WEST SUSSEX COUNTY COUNCIL CONSULTATION

TO:	Arun District Council FAO: Hebe Smith
FROM:	WSCC – Highways Authority
DATE:	30 June 2026
LOCATION:	6 Ormesby Crescent Bognor Regis PO22 8EN
SUBJECT:	FP/55/26/PL Demolition of garage and conservatory, extension and alteration of existing bungalow to create two separate dwellings including a new crossover to public highway.
DATE OF SITE VISIT:	n/a
RECOMMENDATION:	Advice

Crossover Plan
Scale 1 : 500

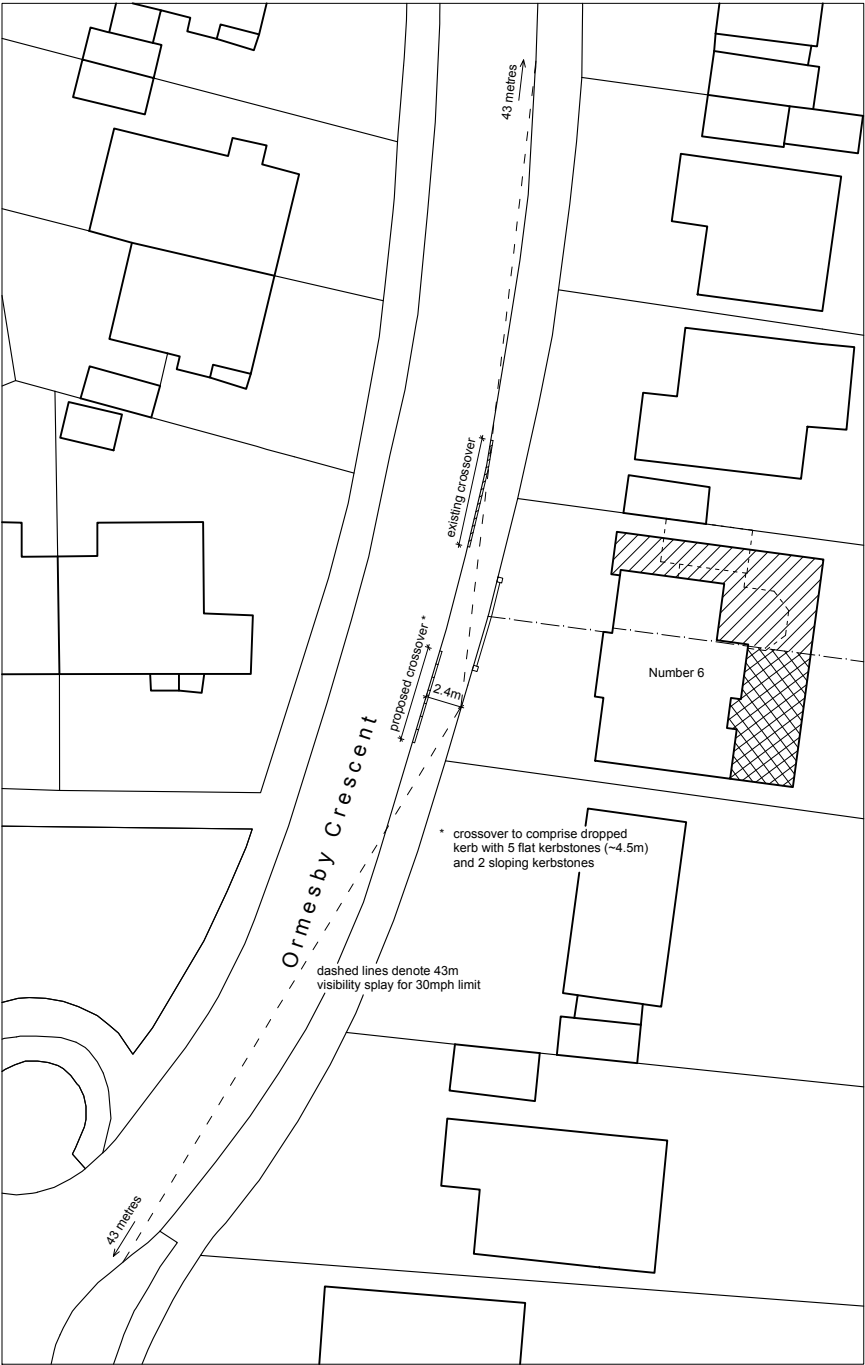
The existing dwelling benefits from a vehicular crossover which will be retained and unaltered. A new vehicular crossover is proposed to serve the additional dwelling. The proposed crossover would be subject to a licence from the WSCC Area Engineer and must be constructed to a specification agreed with them. The LHA would not raise any highway safety concerns to the proposed VCO in this location – visibility appears sufficient for the anticipated road speeds.

No part of the development shall be first occupied until such time as the vehicular access serving the development has been constructed in accordance with the details shown on the approved drawing.

Block Plan
Scale 1 : 500

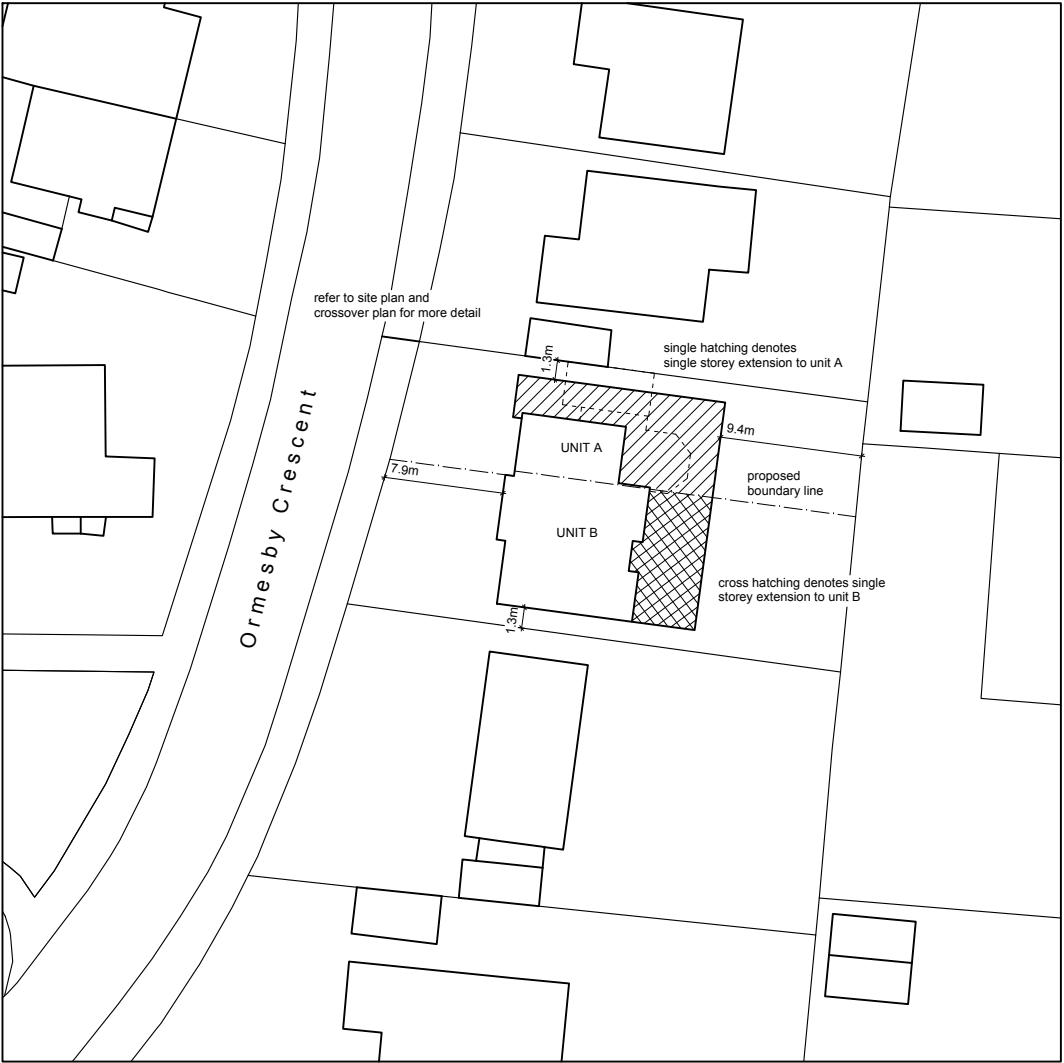
The proposal would result in one two bedroom and one three bedroom dwelling on site. Two parking spaces are proposed for each dwelling. The WSCC parking demand calculator would expect that three parking spaces are required for the proposed three bedroom dwelling. As such, the proposal has potential to result in the requirement for one overspill parking space which would have to be accommodated on street. The LHA would not raise a highway safety concern to the proposed parking provision, however the LPA may wish to consider the potential impacts of this development on on-street parking from an amenity point of view.

The plans indicate that secure and covered cycle parking will be provided in each rear garden to encourage sustainable transport methods. The site is located within an existing residential area within proximity to local services and schools.

No part of the development shall be first occupied until the car parking has been constructed in accordance with the approved site plan. These spaces shall thereafter be retained at all times for their designated purpose.

No part of the development shall be first occupied until covered and secure cycle parking spaces have been provided in accordance with the approved site plan.
